Job ID: 2011-07-1799-SF

has permission to Build a New Single Family Residence.

**From:** Jonathan Rioux  
**To:** dananderson2@myfairpoint.net  
**Date:** 8/16/2011 8:57 AM  
**Subject:** 64 Gertrude Ave.

FRONT ELEVATION

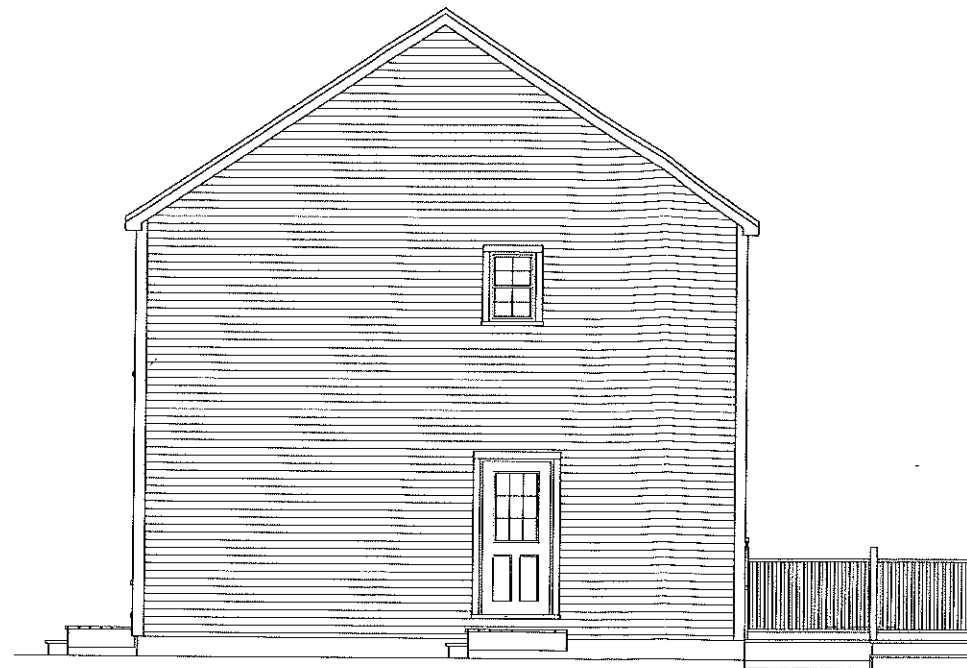
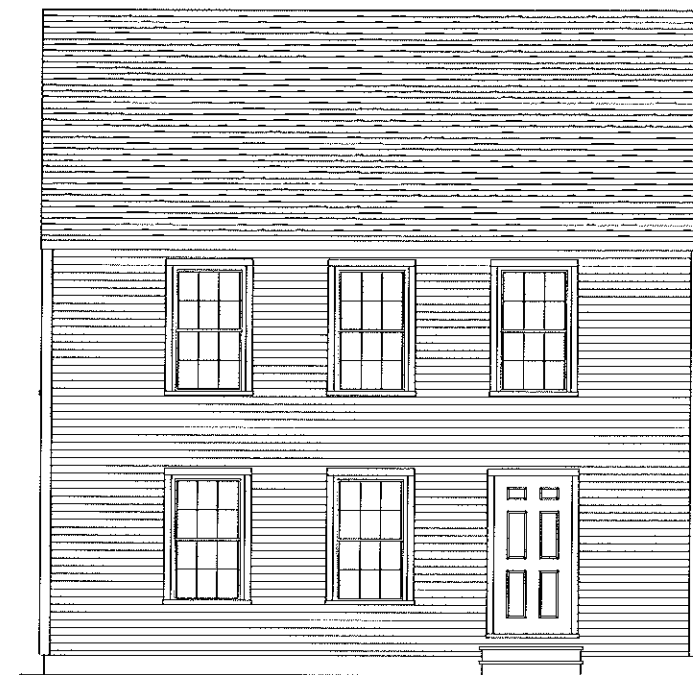
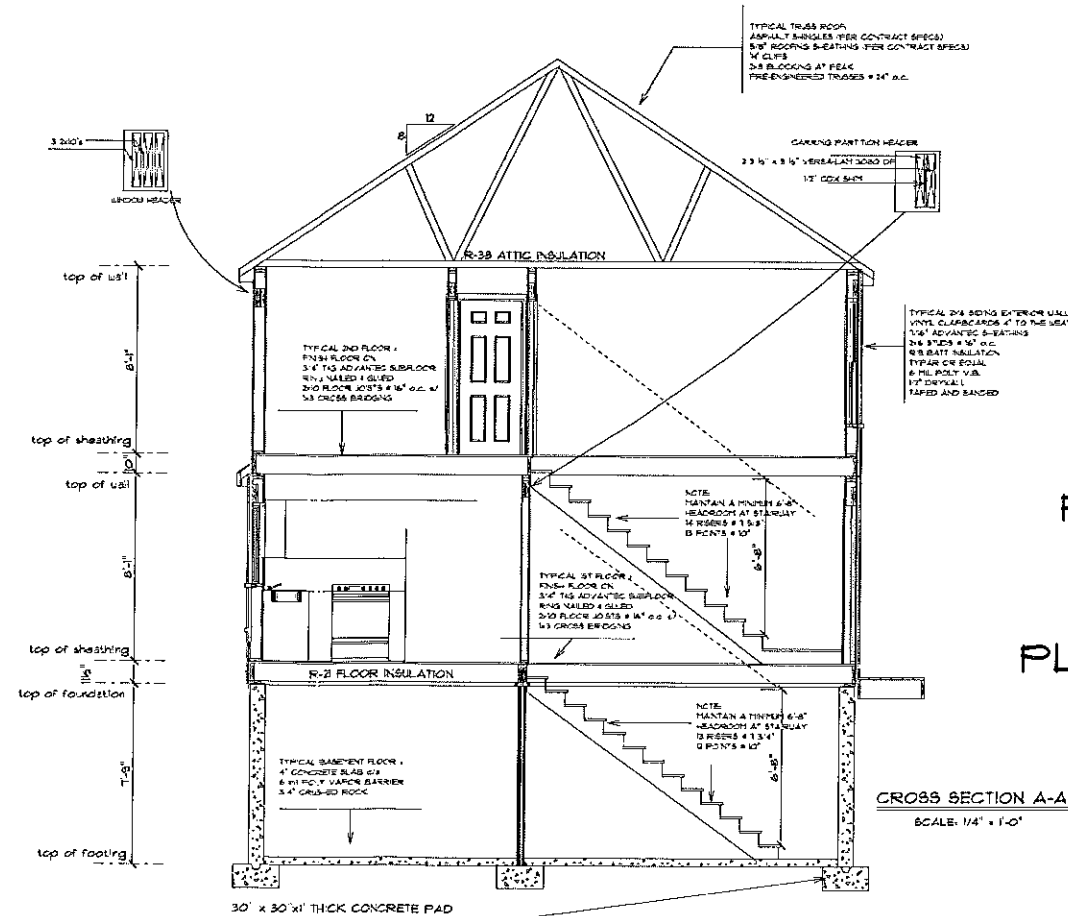
**Windows:**

- Window sills in locations more than 72 inches from finished grade shall be a minimum of 24 inches above the finished floor of the room, unless a window fall prevention devices is installed in accordance with section R612.3.
- A code compliant emergency escape shall be provided in the bedroom. Window sills in locations more than 72 inches from finished grade shall be a minimum of 24 inches (no higher than 44 inches) above the finished floor of the room.

**Deck Construction (R502.2.1)**

- Beam sizing and spans
- Fall protection/ overall height from grade?
- Stair Specs

2. Window sills in locations more than 72 inches from finished grade shall be a minimum of 24 inches above the finished floor of the room, unless a window fall prevention devices is installed in accordance with section R612.3.

9. Mechanical or natural ventilation required in the bathroom
10. R502.2.2 Decks. Where supported by attachment to an exterior wall, decks shall be positively anchored to the primary structure and designed for both vertical and lateral loads as applicable. Such attachment shall not be accomplished by the use of toenails or nails subject to withdrawal. Where positive connection to the primary building structure cannot be verified during inspection, decks shall be self- supporting.
11. Note: Contractor will submit Engineer Beam specifications, Girder/ Header Sizing and Spans (Including Deck/Porch Framing), and compliance with the IECC prior to constructions.
